APPROVED
Limited building only review.
Permit holder responsible for full compliance with the code.

FRONT ELEVATION
SCALE: 1/4" = 1'-0"

Jerry/Jodie Brock
Neill's Creek Road
Angier, NC

SHEET
A-3

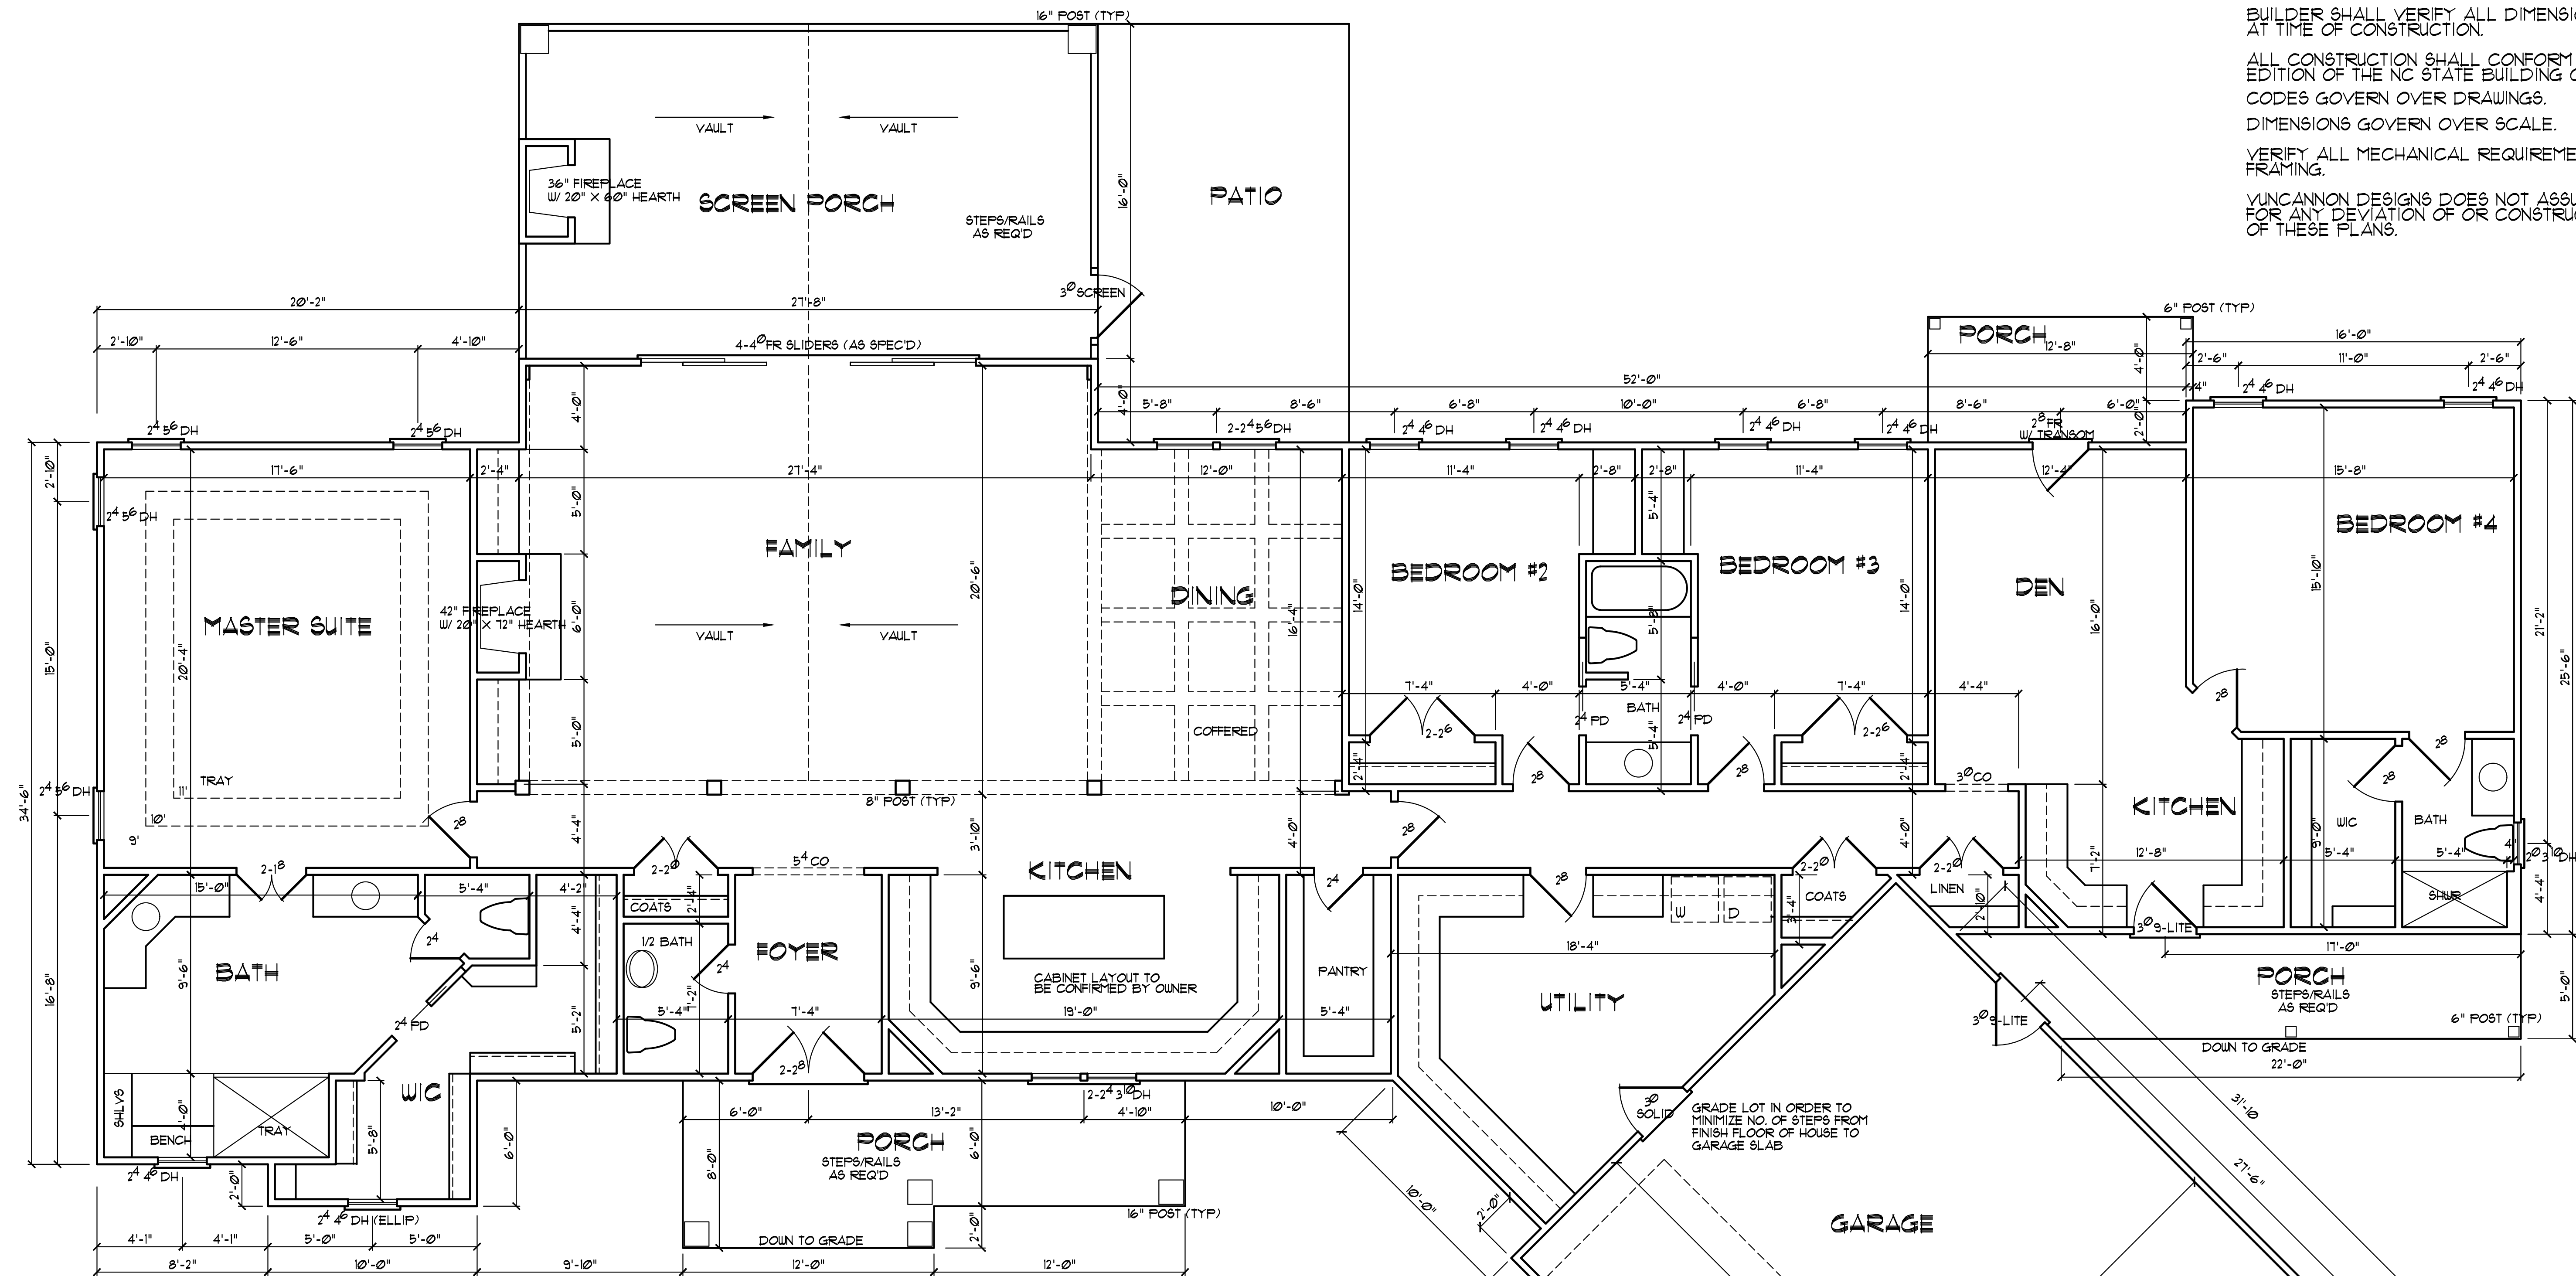
See notes on floor plan. Windows shown in bedrooms will not meet egress requirements. Field verify correction

These windows will not meet egress requirements
